Our Ref: AB/49/17/L

Application for Listed Building Consent for Alterations, Extension or Demolition of a Listed Building

Development Application for listed building consent for conversion of a mixed use space into a new ground floor studio apartment and regularisation for consent for new stud work for partition wall.

Location 55-57 High Street 57 High Street Arundel

ELEVATIONS -EXISTING - PROPOSED

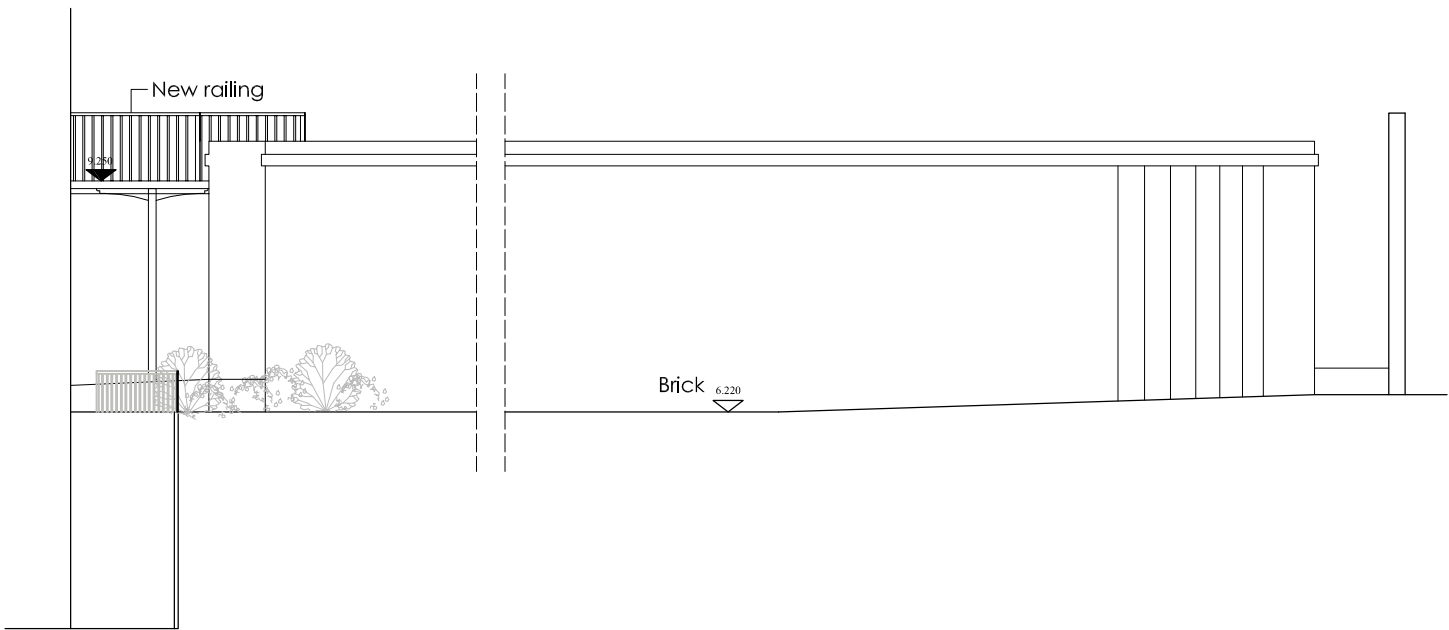
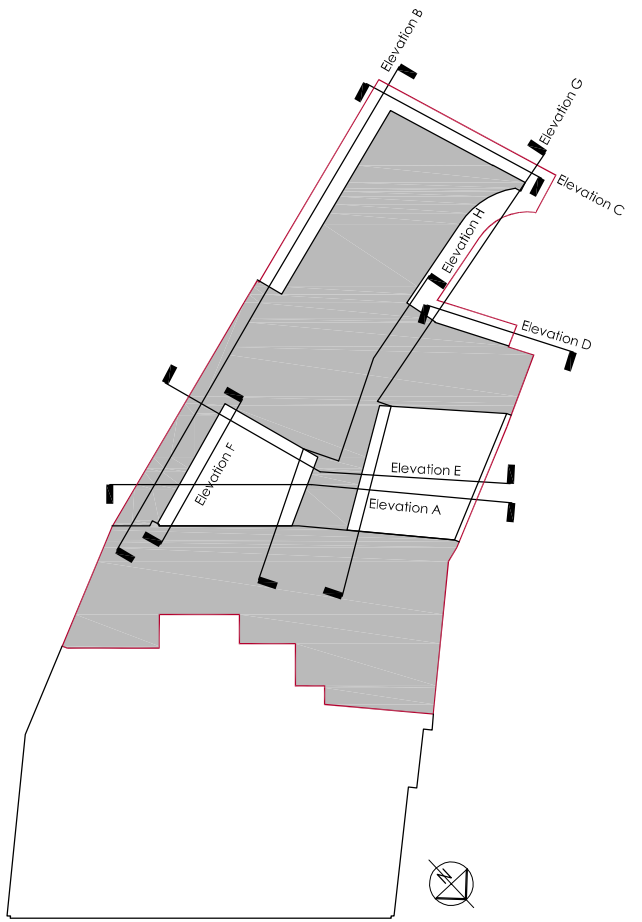
Please provide elevations of the two outbuildings from the centre passage way to show the changes to the removal of courtyard walls
